Our Ref: FP/214/18/CLP
Your Ref:

Application for Lawful Development Certificate for a Proposed Use or Development

Development Application for certificate of lawfulness for a proposed use - single storey ground extension
Location 9 Alfriston Close Felpham

Existing Grounds for
Exhibition Area.
August 2018.

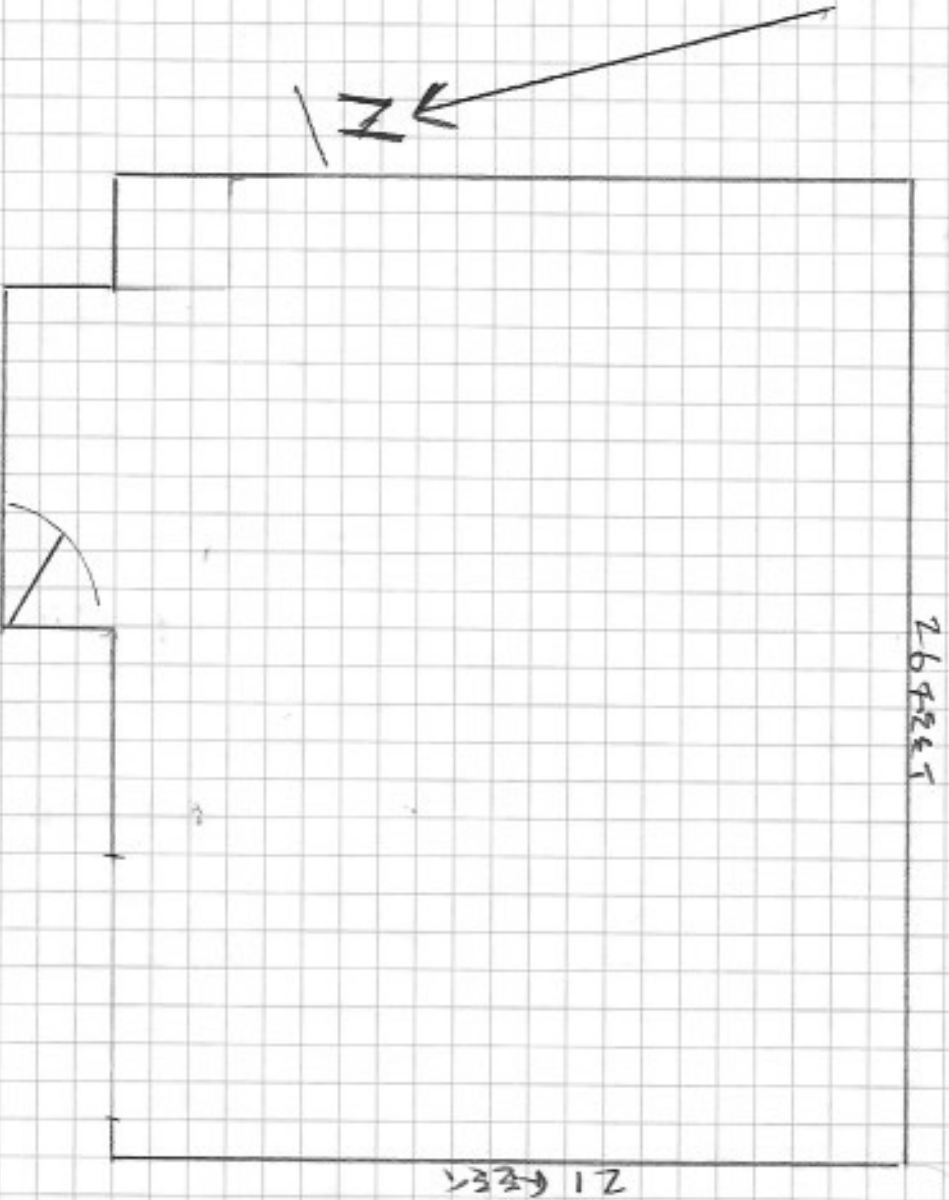
The existing floor plan needs to be to scale. Please forward amended to scale (metric)
